Ref: DOC16/316742  
Your Ref: SSD 7372

**Re: Heritage Council comments on State Significant Development Application (SSD) for the New O'Connell Street Public School, Parramatta: SSD 7372.**

Figure 96: Location of potential significant historical archaeological remains.

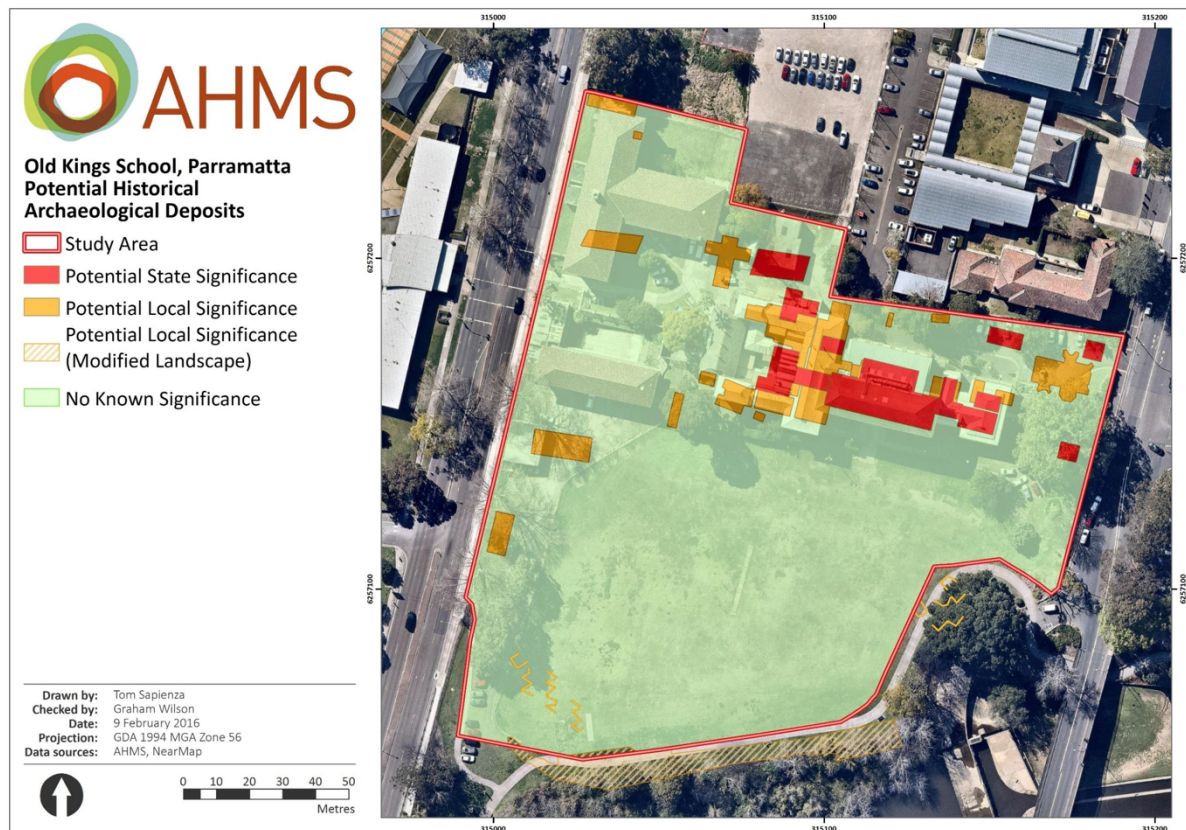
In addition, the Extent assessment (such as Figure 15) does not clearly show all areas of proposed impacts against the areas of assessed potential/significance, specifically decontamination of land and service upgrades are missing from this consideration. The Extent assessment is also unclear what impacts to subfloor deposits may occur within Buildings A, B and C1, which have been clearly identified in the 1994 CMP and 2004 Assessment as to be retained unharmed *in situ*. Impact to subfloor deposits in these areas should be avoided during the works.

Two areas have potential to contain state significant archaeological deposits where impact is proposed. These include the refurbishment of the Marist Place carpark and the new covered sports court north of Building C. The impact to the two items identified within the carpark in Figure 14 as items 12 and 14 should be avoided during the refurbishment, and protection systems positioned to ensure this. The new covered sports court north of Building C has the potential for local and state significant relics in this area, although previous disturbance through the services in this area and the underground storage tank decontamination works may have impacted this resource to an uncertain degree.

14. The SOHI Historical Archaeology should be amended prior to approval of this project to include a detailed significance assessment with consideration of comparative analysis where necessary. This should inform any revision of Figure 14. Figure 15 and the section of impact analysis should also include consideration of impacts from other portions of the project such as services upgrades where new trenches are proposed and activities required to decontaminate land.

16. Test excavation prior to confirming the detailed footing design for the new covered sports court north of building C should be undertaken to confirm the presence of local and state significant archaeological evidence; the level at which such evidence exists and its integrity. Where state significant relics are identified, footing options for the new building should be amended avoid harm to these remains and they should be retained *in situ* unharmed.
